Your Ref: OWPC24197
Our Ref: LU/249/19/PL 01-08-2019
Please ask for:
Richard Castro-Parker

Change of use of No 48 from Licenced Betting Office & Adult Gaming Centre (Sui Generis) to Retail (A1 Shops) & No 50 from Retail (A1 Shops) to Licenced Betting Office & Adult Gaming Centre (Sui Generis).

48 & 50 High Street Littlehampton

No.50 EXISTING FLOOR PLANS & SHOP FRONT | 1:100

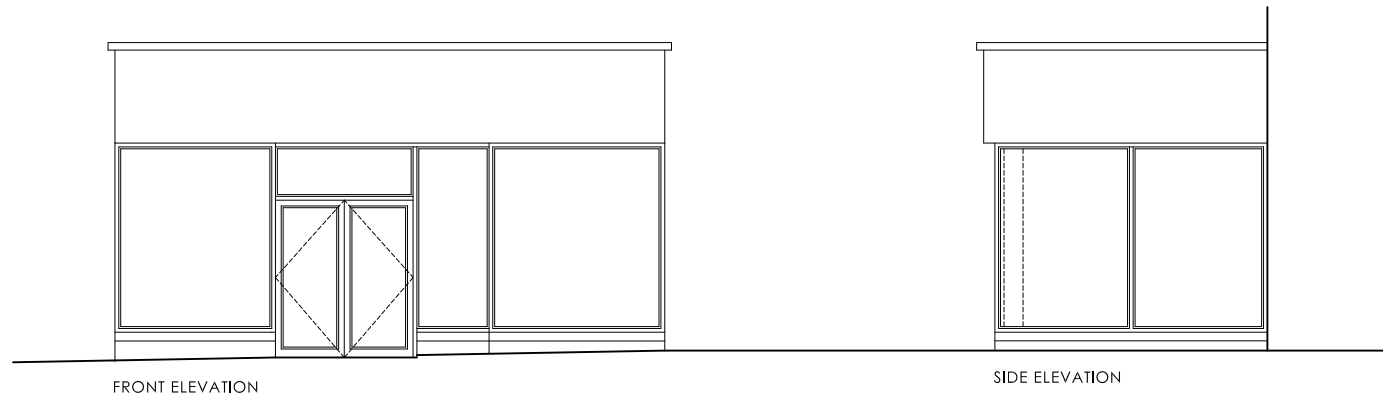
The increase in floor space and more prominent location of 50 high street should be considered.

Planning policy states that 'window display should be appropriate to a shop front which is in keeping with the character of the shopping area'. There is no visual of the new signage and display and this should be seen before consent is granted given the more prominent nature of the new frontage for the betting shop and adult gaming centre.

50 High Street is on the Arun local list of buildings of special character yet this is not acknowledged in the application nor any explanation as to how the application responds positively to the designation.
